From: Sarah Fawdry [REDACTED]
Sent: 02 March 2023 15:55
To: Jessica Riches; David Easton
Cc: Chris Brake; Katie Martin; Martin Kempshall; Thomas Richards; Silvie Steiningerova
Subject: Bilsham Road, Yapton - Y/70/22/DOC and Y/34/22/DOC
Attachments: 2023 02 08 Y 70 22 DOC Drainage Response.pdf; D1956-13-200B Proposed Levels Layout.pdf; D1956-13-201B Proposed Levels Layout.pdf; D1956-13-202B Proposed Levels Layout.pdf; D1956-13-300B Proposed Permeable Paving Formation Levels.pdf; D1956-13-301B Proposed Permeable Paving Formation Levels.pdf; D1956-13-302B Proposed Permeable Paving Formation Levels.pdf

Having recently picked up comments on your online portal regarding Y/70/22/DOC (dated 8 February 2023; attached for ease), please find our responses to the outstanding queries as follows. For ease and completeness, I have followed on from the previous queries with our responses, our latest response is detailed in green.

CLASS S PIPE BEDDING & SURROUND (NTS)
CLASS Z PIPE BEDDING & SURROUND (NTS)

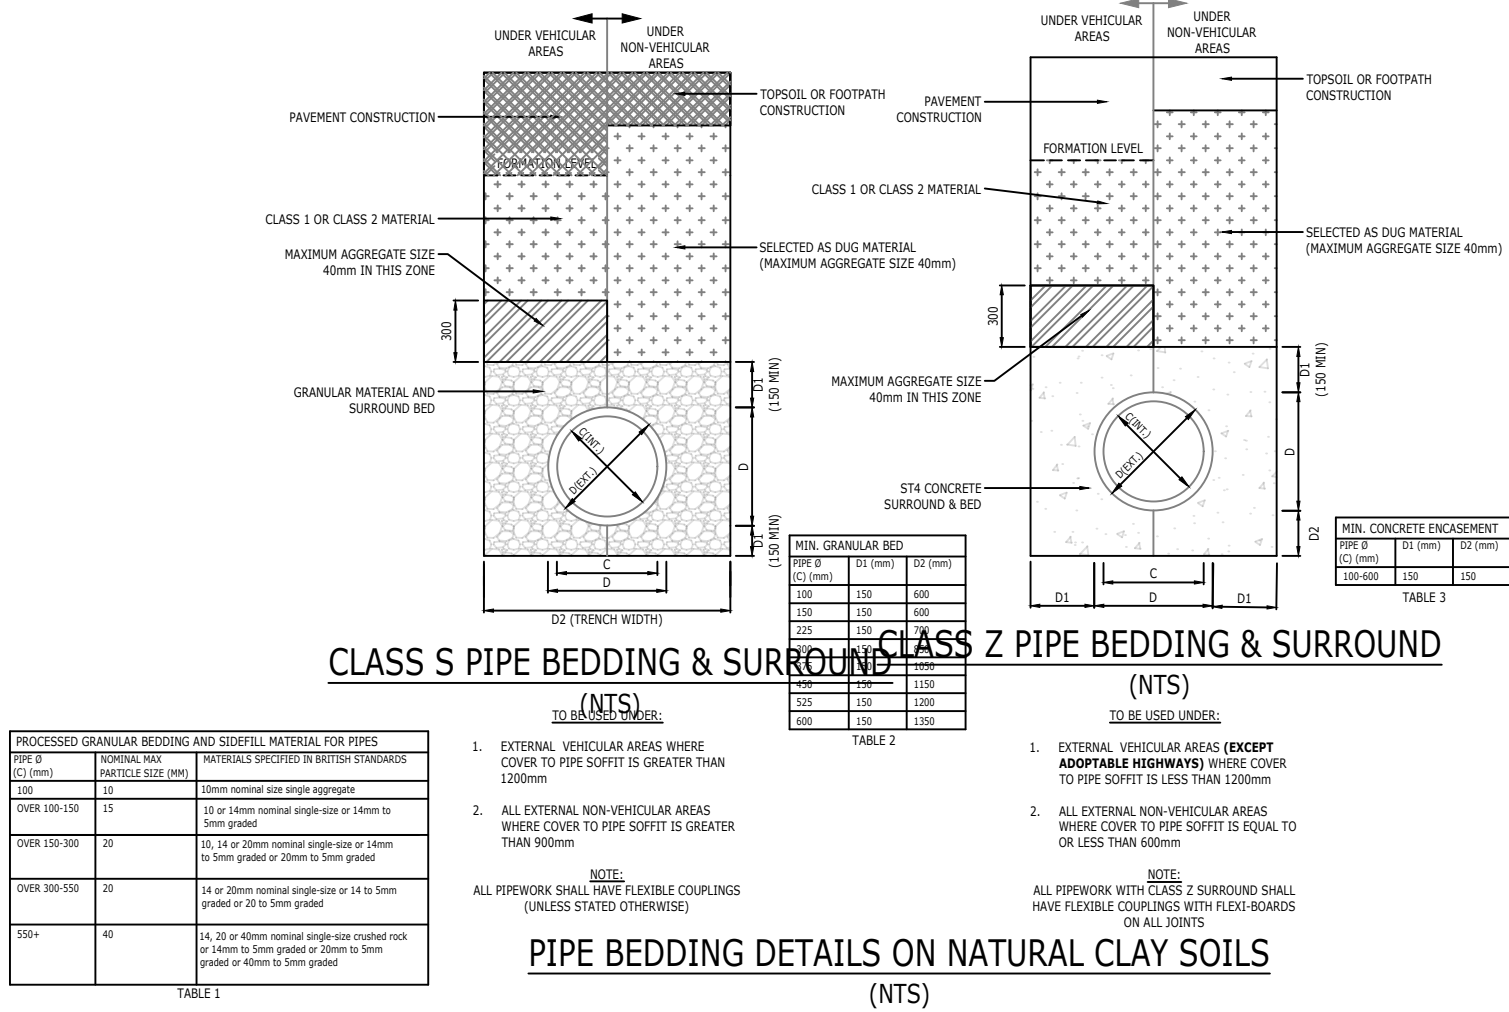
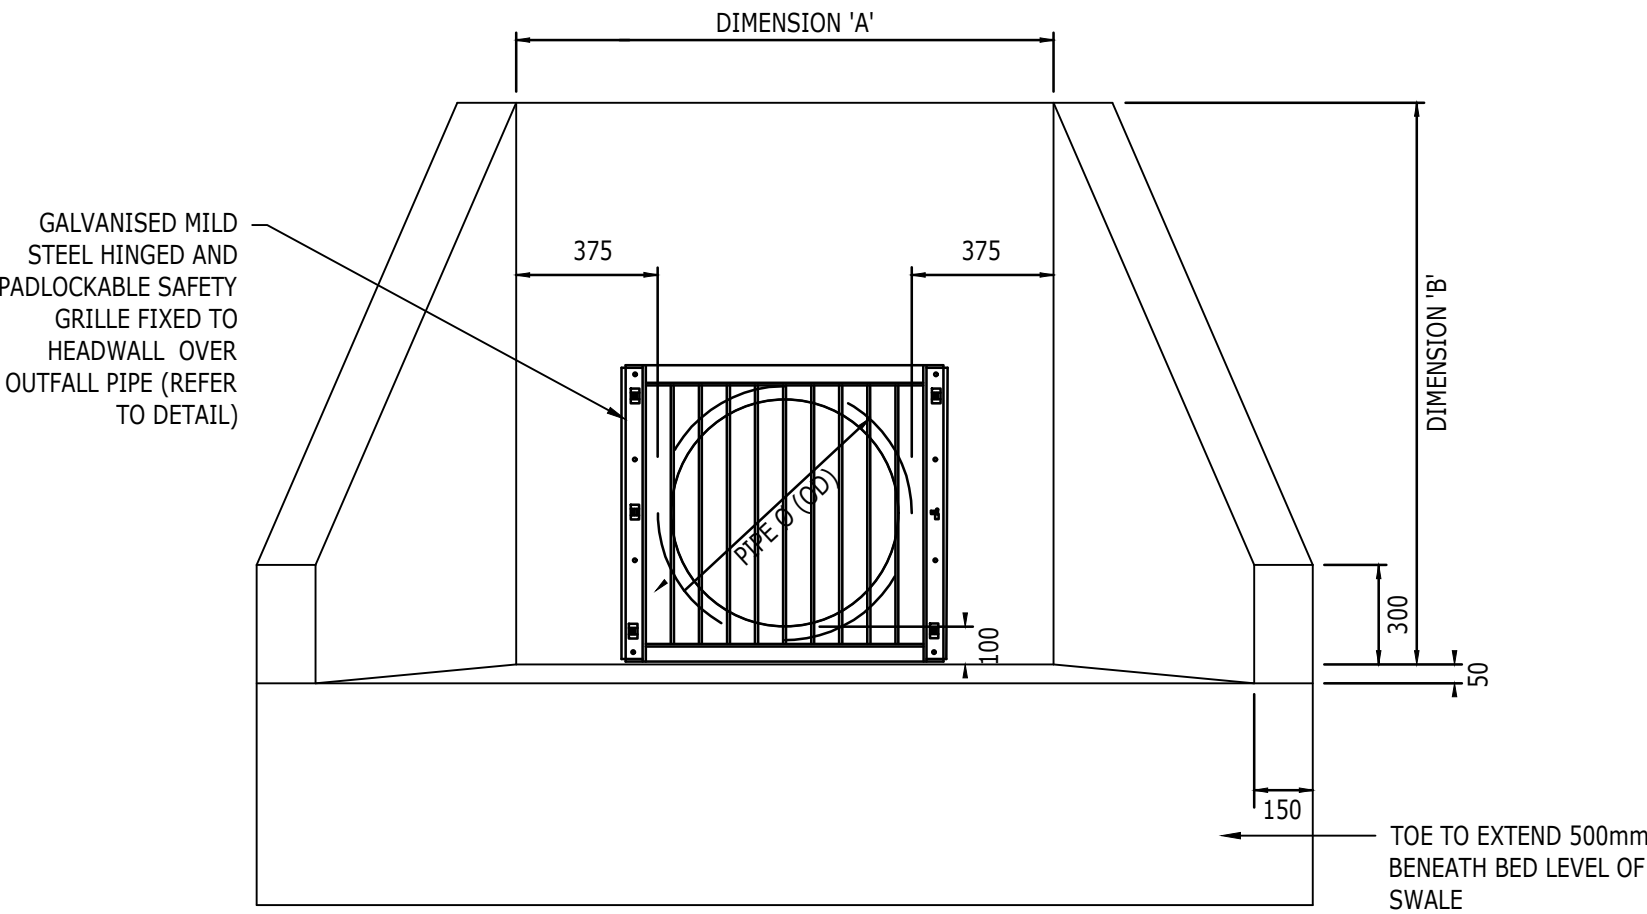
11. Please provide cranked grilles at a 45 degree angle. - Cranked grilles required on heads – S104 Construction details sheet 1 of 2 D1956-15-100 needs to be updated to suit ADC requirement. Pipe beddings details on this drawing are illegible in parts. Information needs to be clearly presented. We note that applicant's response that this is not "DSG compliant" however the drawings refer to Sewers for Adoption 7th Edition. As such the applicant needs to be clear which edition of Sewer for Adoption the adoptable drainage is being designed to. In addition they should confirm who the adopting authority will be as well as confirmation from the adopting authority on whether they will or will not accept cranked grilles. 08/02/2023- Whilst it is noted that the Technical Approval certificate has been provided for information, this doesn't clarify whether the adopting authority has considered a request to use cranked grilles. This needs to be confirmed by the adopting authority otherwise cranked grilles should be used TH: There is no provision in DCG for the use of cranked grilles, only grilles installed flat against the headwall. In addition, we consider that cranked grilles create a health and safety issue as they could encourage people to climb up on them up to a perch from which people could fall.
